CAWSTON PARISH COUNCIL COMMENTS OS SUBMISSIONS FOR DEADLINES 6 TO 9, NORFOLK BOREAS OFFSHORE WINDFARM , DEADLINE 10.

Cawston PC wishes to submit the following for Deadline 10. These are responses to key points noted in other submissions from Deadlines 6 to 9.

Highway Intervention Scheme

CAWSTON HIGH STREET - INTERVENTION SCHEME  
Scale 1:500

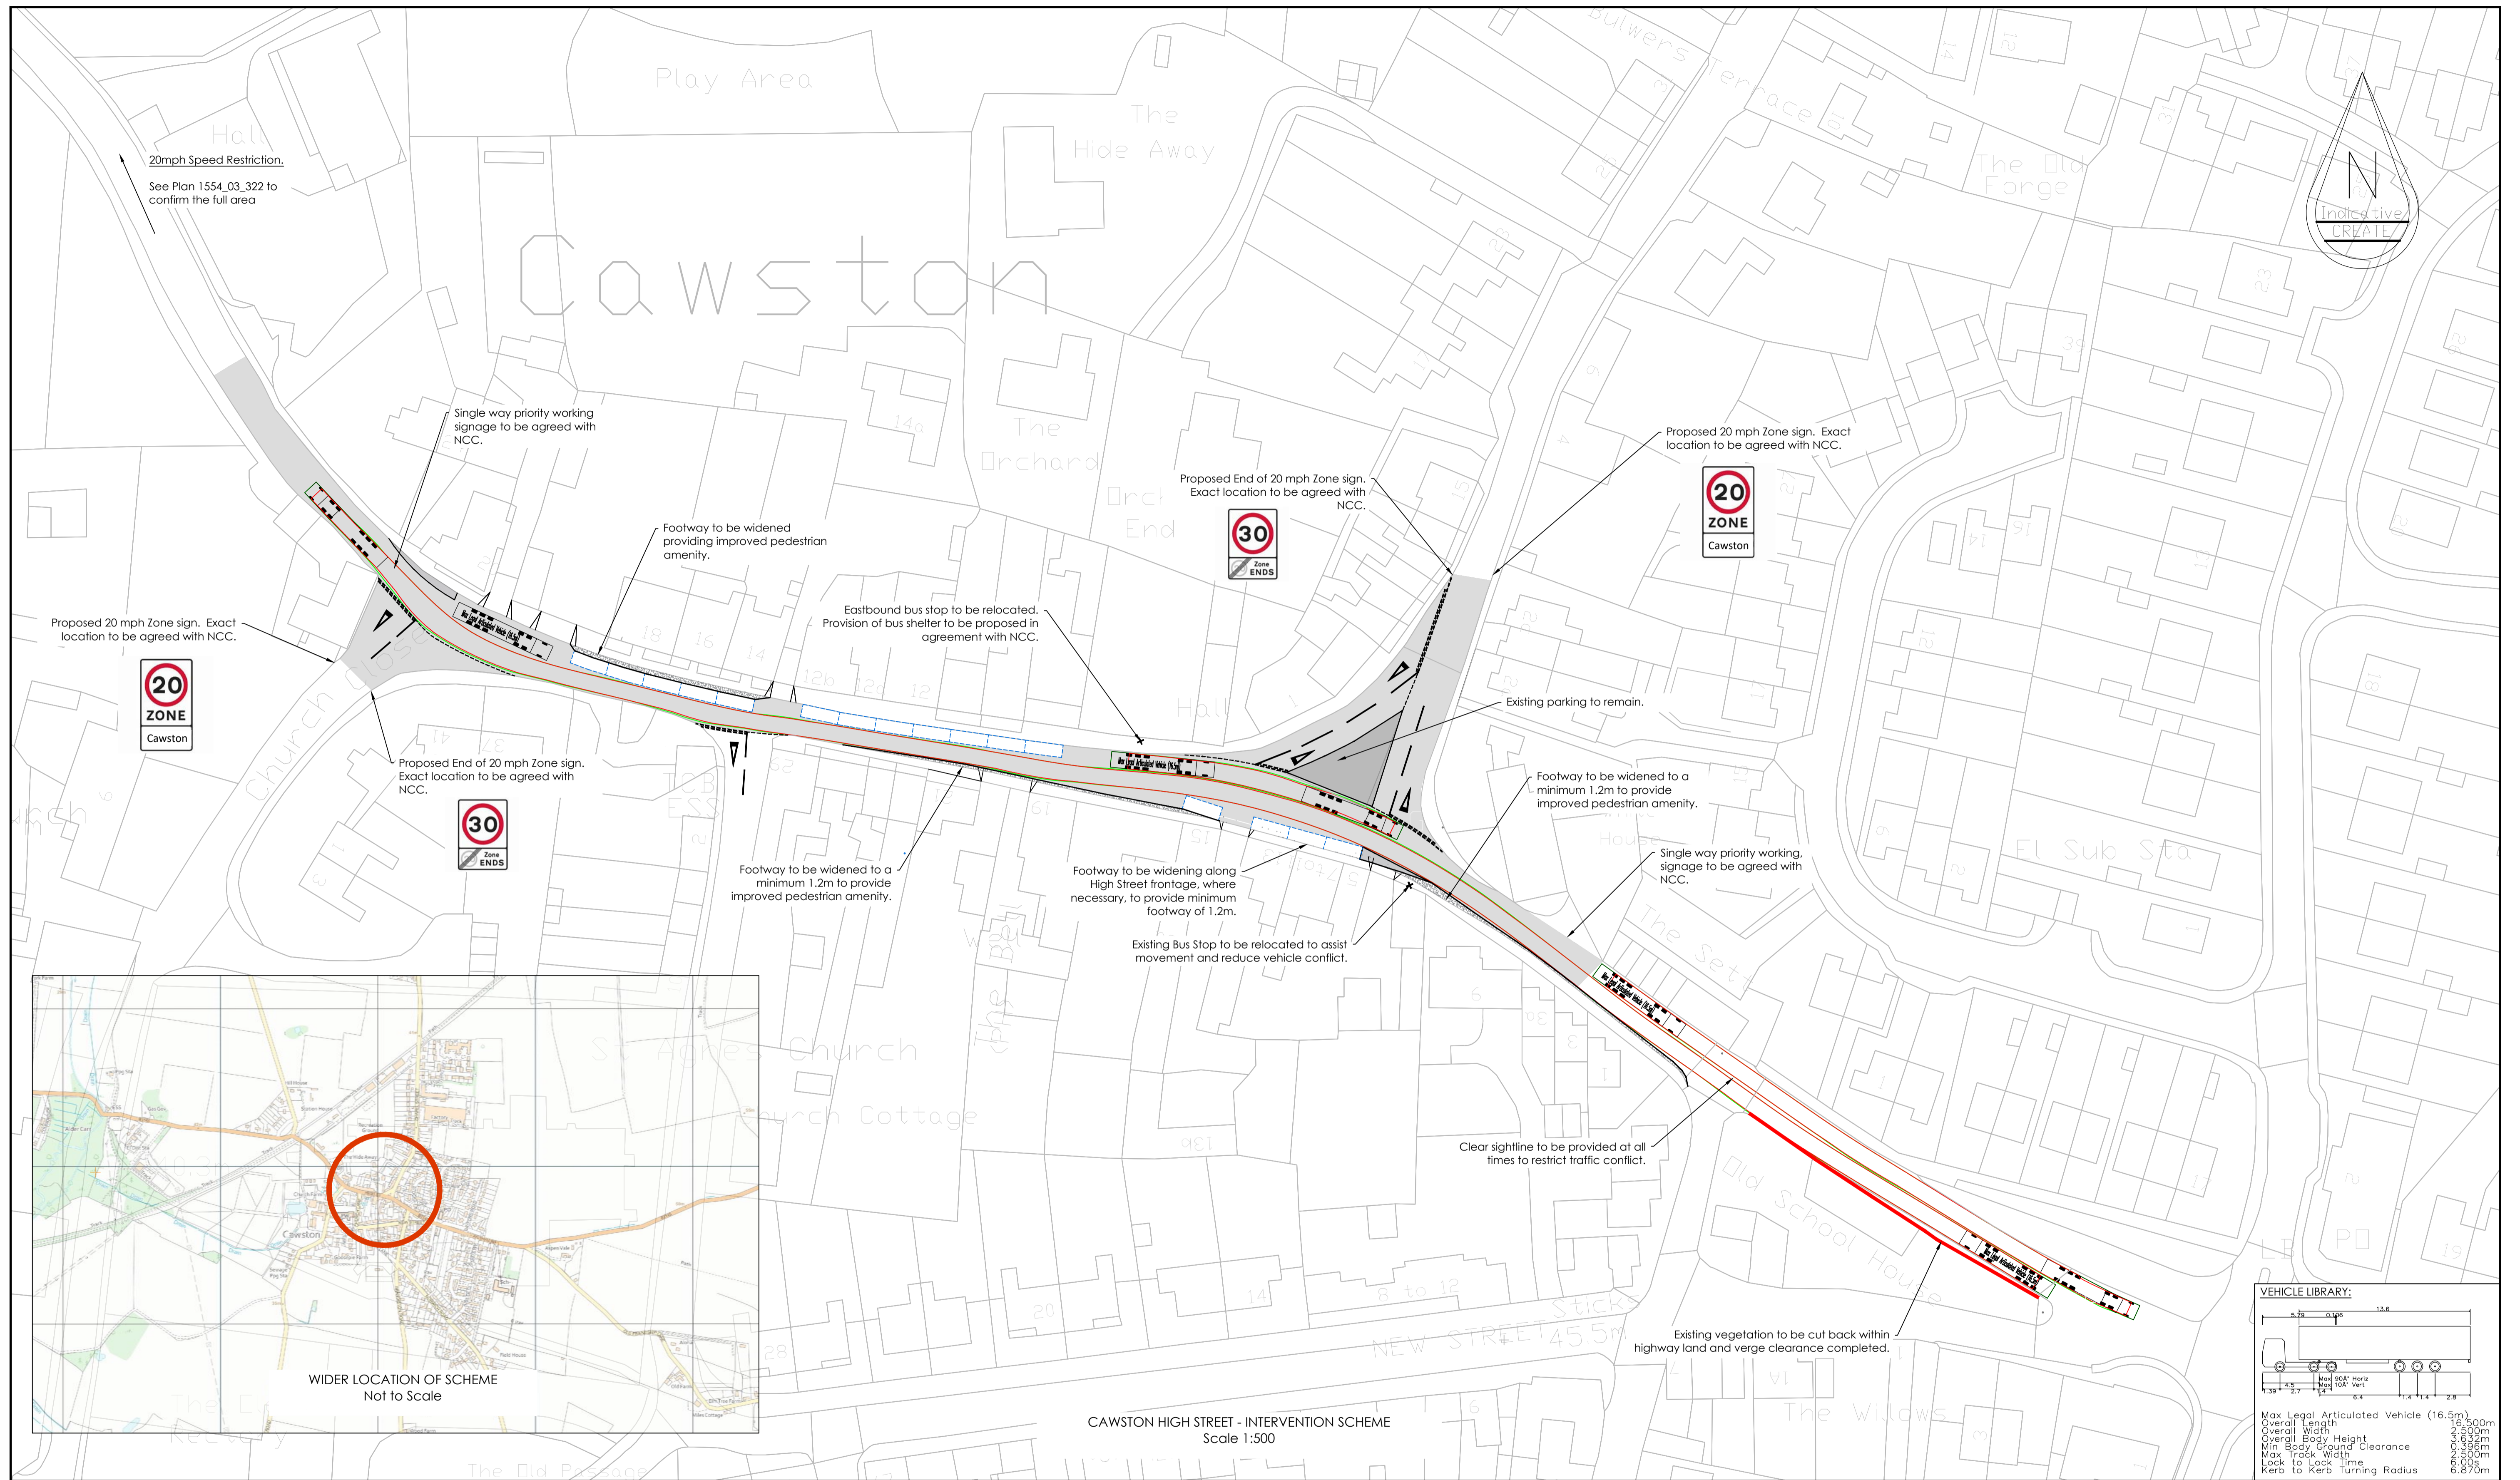
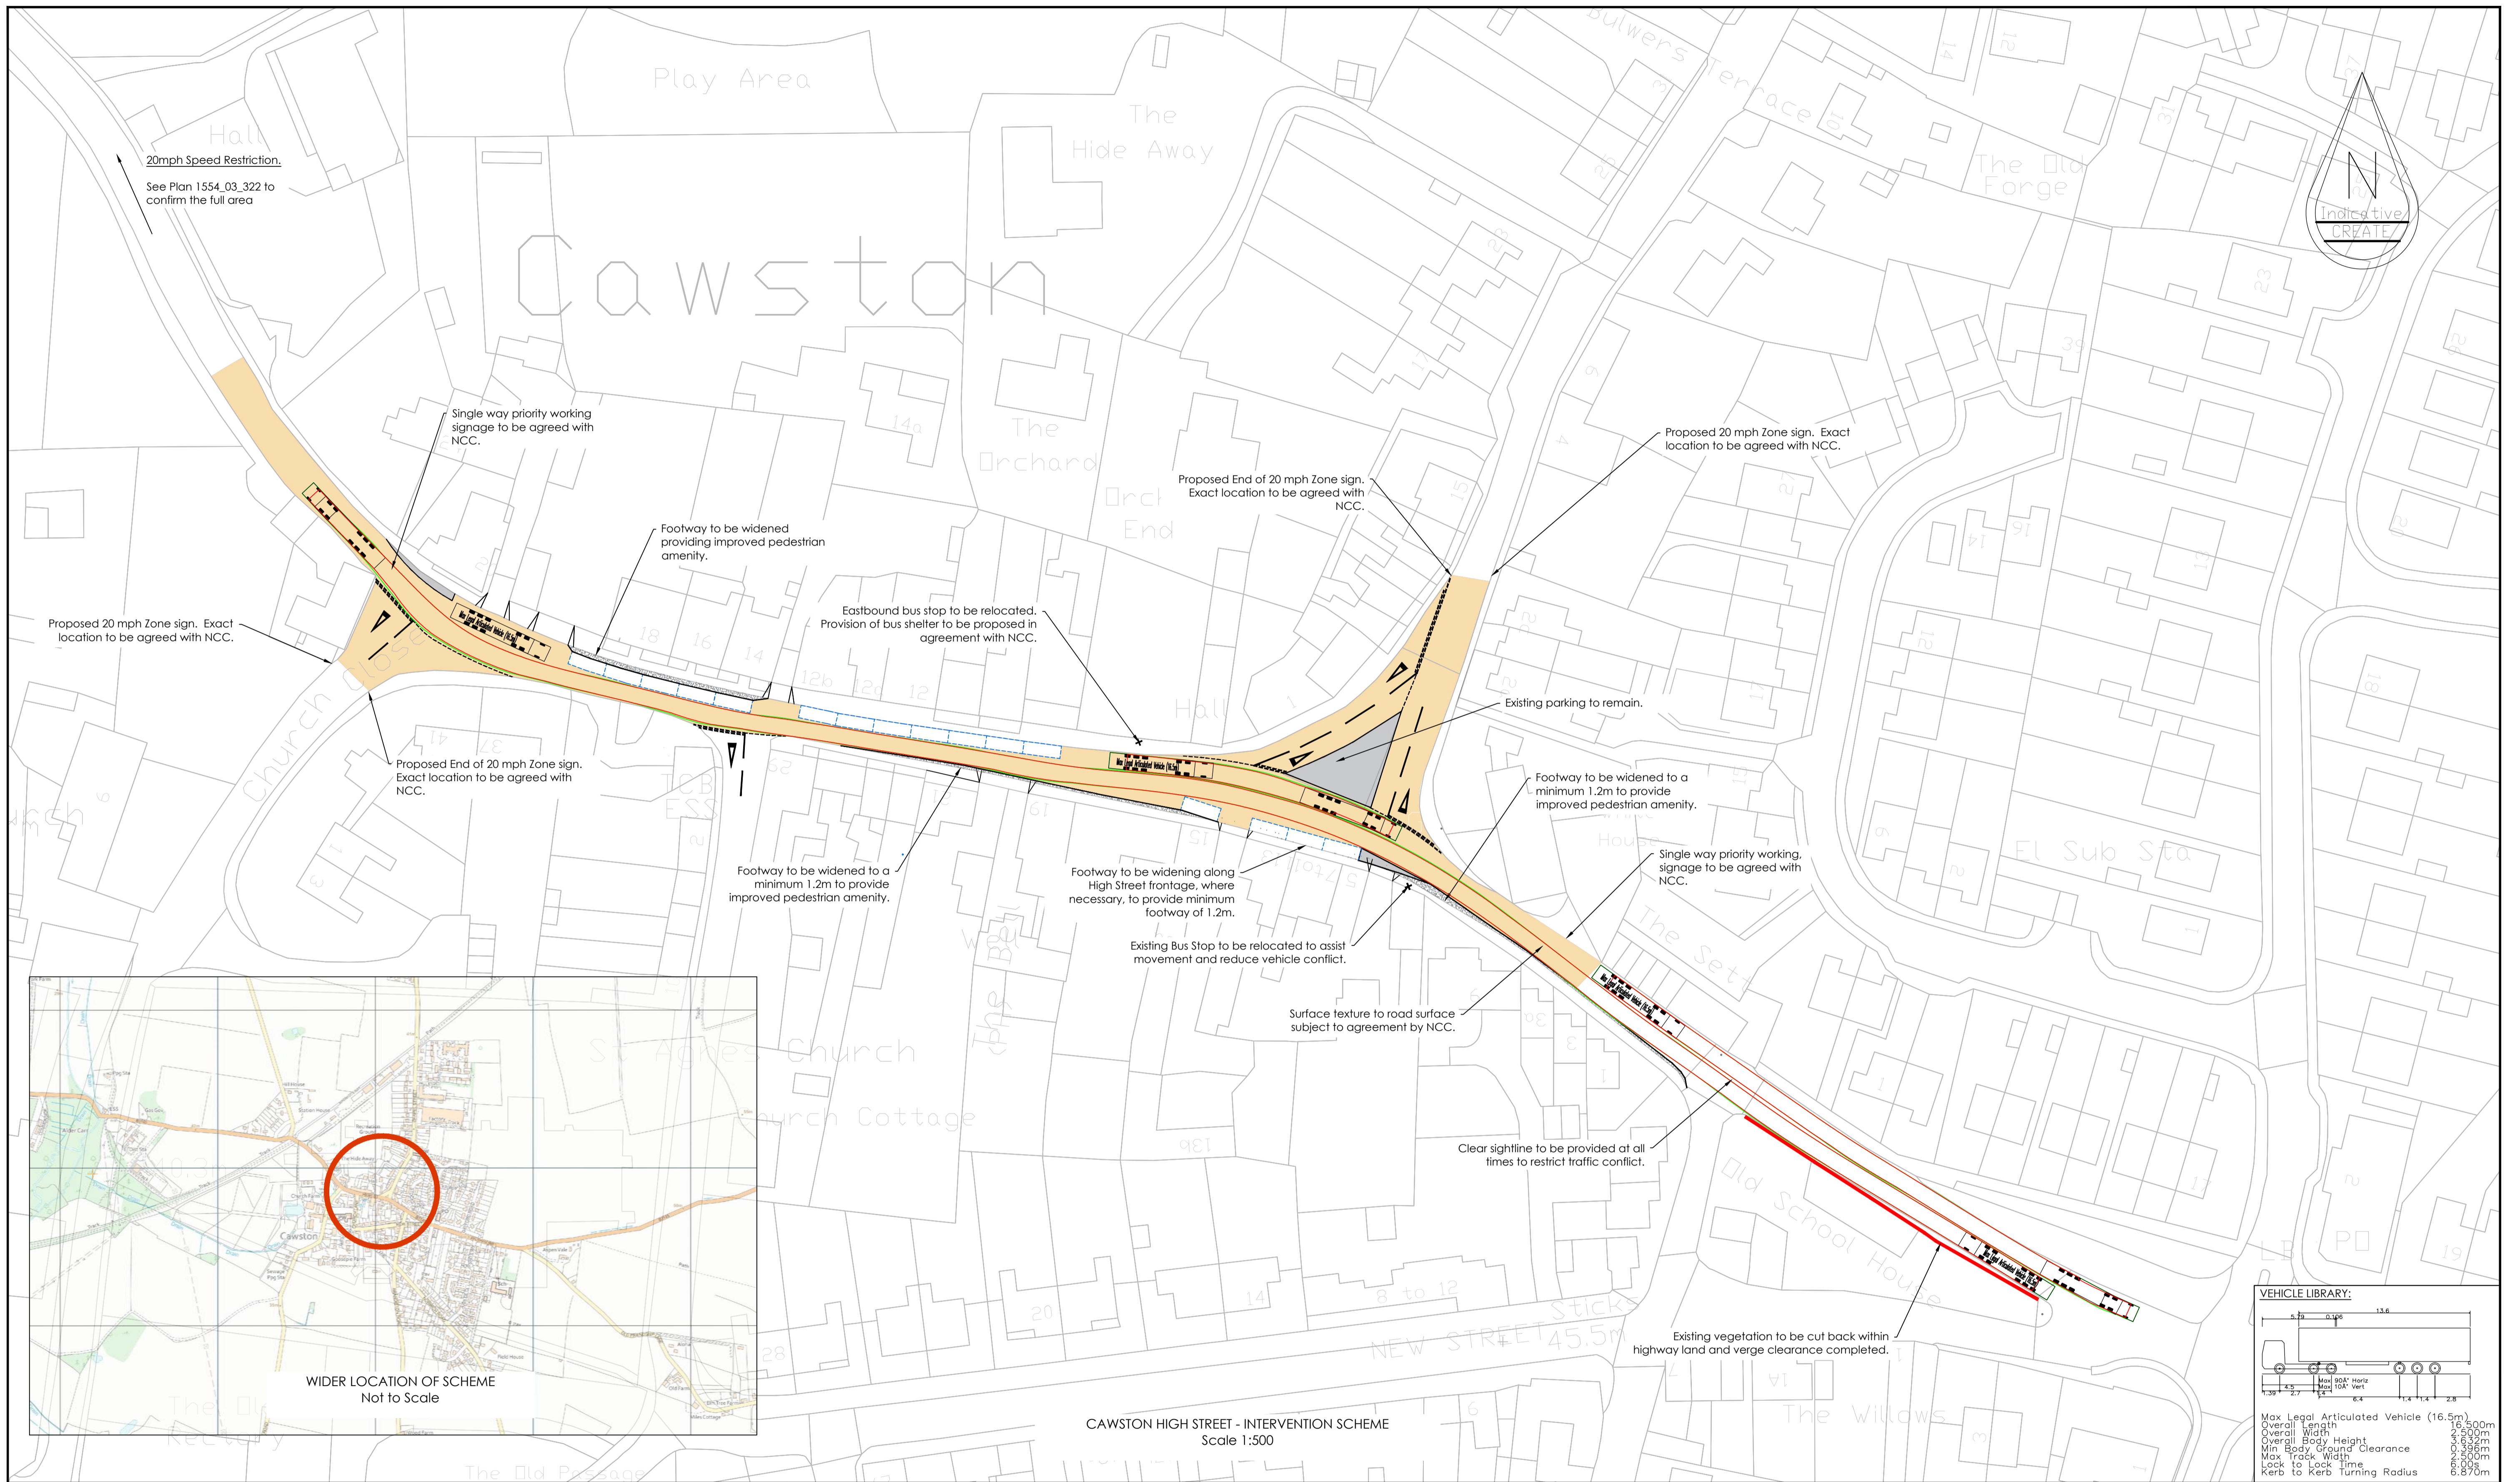
The Applicant supplies further drawings which purport to show how HGVs and other vehicles should be able to pass each other. These drawings show that in many parts of the village the tracks of vehicles pass so close as to be indistinguishable at the screen resolutions available to Cawston Parish Council, demonstrating that in much of the village HGVs are unable to pass safely.

The additional width of vehicles from wing mirrors is not shown in the drawings and even in the areas designated for passing the additional width for two sets of wing mirrors and a safe passing distance between them is not evident.

1. The ability of all HGV drivers to be able to see oncoming traffic around corners on the bend at the railway bridge, on the bend by the Old Forge and on the bend close to White House Farm
2. A requirement for all HGVs, not only the Applicant's and/or Hornsea 3 project HGVs, to arrive at evenly spaced intervals
3. Where two HGVs approach from either East or West they must not have any other road traffic between so they can fit in the proposed system of "passing places". Any train of vehicles longer than the planned "passing space", which is designed for two HGV lengths, will obstruct passing manoeuvres and make gridlock more likely.
